From: Claire Potts
Sent: 04 January 2018 17:13
To: Planning.Responses
Subject: FW: AL/102/17/RES - Nyton Nurseries
Importance: High

From: Michael Olliff [REDACTED]
Sent: 29 December 2017 16:42
To: Claire Potts
Cc: David Maddox; [REDACTED] Cllr. Norman Dingemans; Cllr. Philippa Bower; Cllr. Phil Hitchins; Cllr. Susan Bence; Cllr. Richard Bower; Cllr. Jim Brooks; Cllr. Colin Cates; Cllr. Pat Dillon; Cllr. Alan Gammon; Cllr. Dawn Hall; Cllr. Stephen Haymes; Cllr. Dougal Maconachie; Cllr. Barbara Oakley; Cllr. Vicky Rhodes; Cllr. Elaine Stainton; Cllr. Paul Wells
Subject: Re: AL/102/17/RES - Nyton Nurseries
Importance: High

Subject: AL/102/17/RES - Nyton Nurseries

(Figure 1; Photograph from Nyton Road; T15 circled)

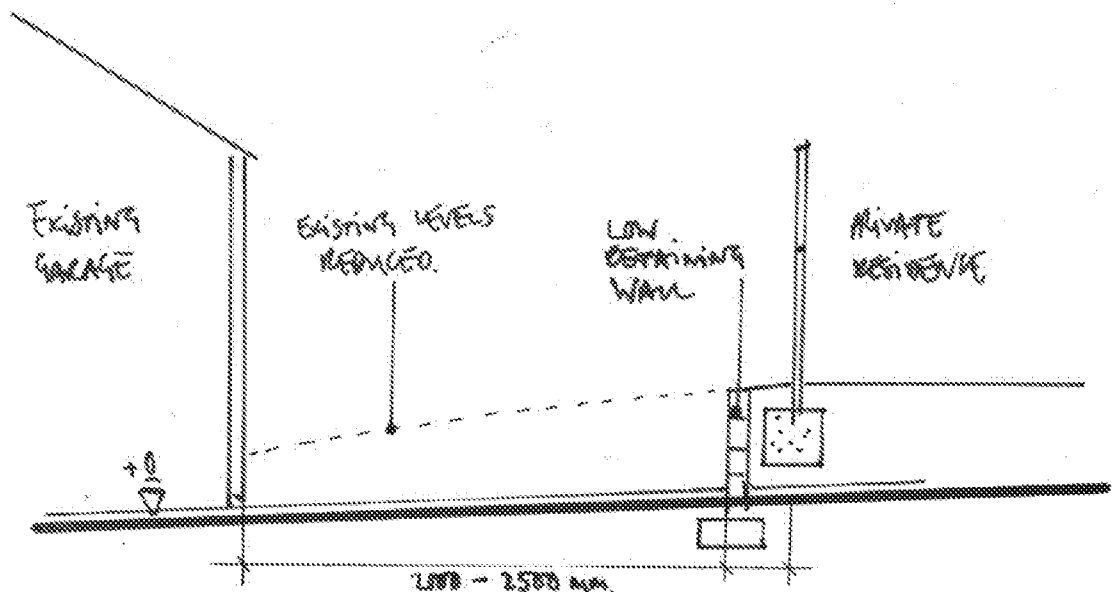
Option 1 - The report states that it "would enable the provision of a formal cycleway of an approximately (sic) width 2.0m - 2.5m". This statement is incorrect as the minimum clear width is 2.51m and in order to construct the retaining wall alongside our boundary this width would be reduced to approximately 2.2m.

The Local Transport Note 1/12 - Shared Use Routes for Pedestrians and Cyclists published by the Department of Transport (attached) requires a minimum effective width of 3m for shared use routes. This is increased to 3.7m where the path is bounded by vertical features (page 41). In addition the maximum gradient permitted approaching a junction is 3% which would require a ramp of at least 16m length which would sever the roots of our Laurel Hedge.

As demonstrated above this proposed route is simply not appropriate as it does not meet the required standards and therefore will be unsafe for the provision of a shared use cycle route. An alternative location must be found and the application to remove tree T15 must be rejected. The Outline Planning Permission was granted on incorrect and insufficient detail and now that we have demonstrated that this route is not suitable then the requirement to provide one must be reconsidered.

As part of the Outline Planning permission, a footpath / cycleway has to be provided in this area (please see attached). The document attached illustrates that removing the tree (through a TPO application) will provide a safe and up to standard cycleway / footway that can be accessible to all within the community. You may remember we did raise this at the Parish Council meeting and the members did explain that they would like to see all TPO's kept, however, in this instance, it would be sensible to remove the tree.

(Figure 4; Illustrative sketch section across proposed footpath showing tree retention / stepped access)

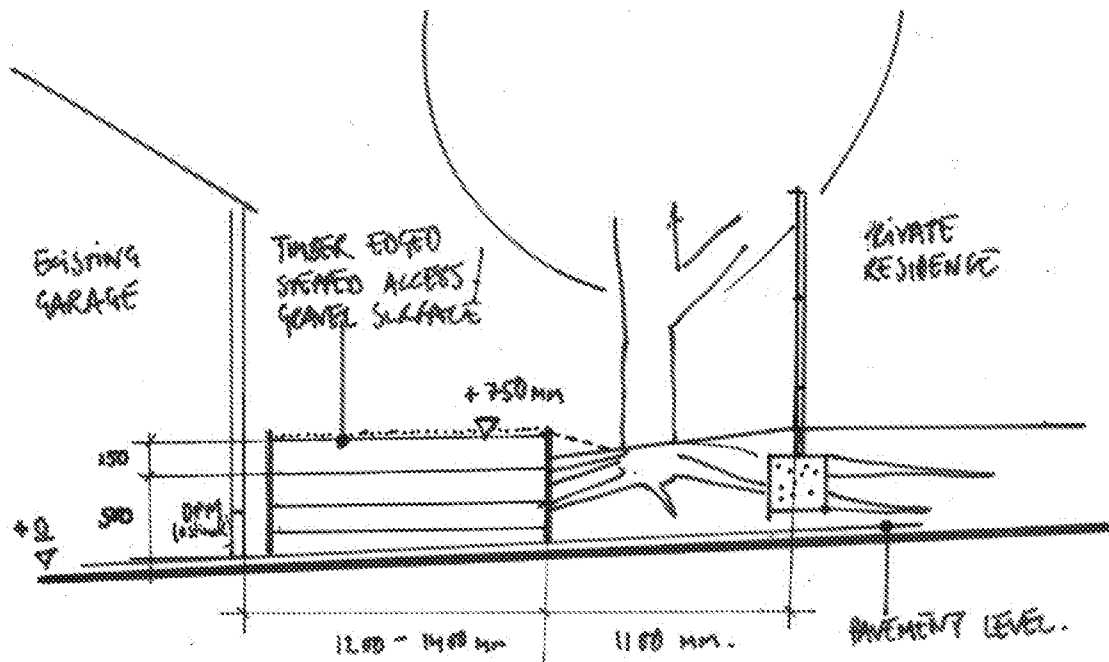
Option 2 - This option requires the construction of a "short steep ramp, or a small set of steps" with a reduced width path of between 1.2m and 1.4m. As noted above this proposal would also not meet the standards required for a shared use cycle route. In addition, if the steps were provided, then there would be a risk of pedestrians tripping, particularly when lighting levels are low which would be very unsafe.
